**Harnett County**  
420 McKinney Pkwy  
LILLINGTON, NC 27546  
Phone:  
Fax:

**SUBJECT: BRES2306-0022**  
**BUILDING RESIDENTIAL**

Here are the results of all Inspections located at **409 LAMBERT LN:**

FOUNDATION PLAN
1/4" = 1'-0"

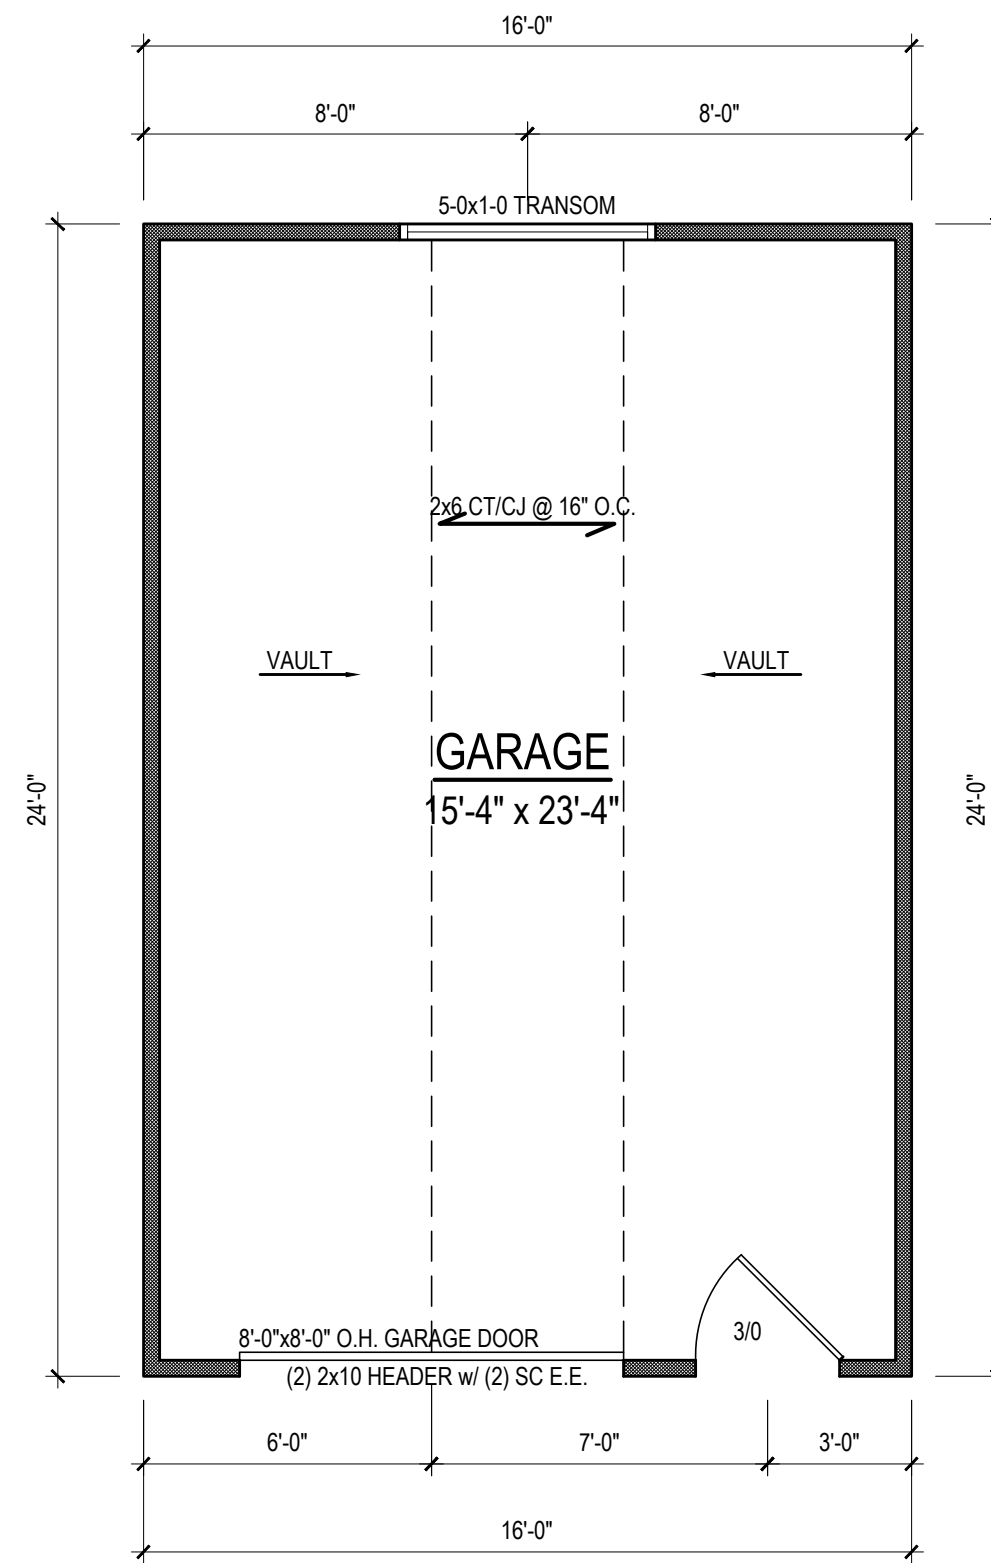
Notes: For mono slab configuration the footing needs to go all the way around the building. As shown on foundation plan for a turndown slab.

Notes: Previous item done. Footing is continuous
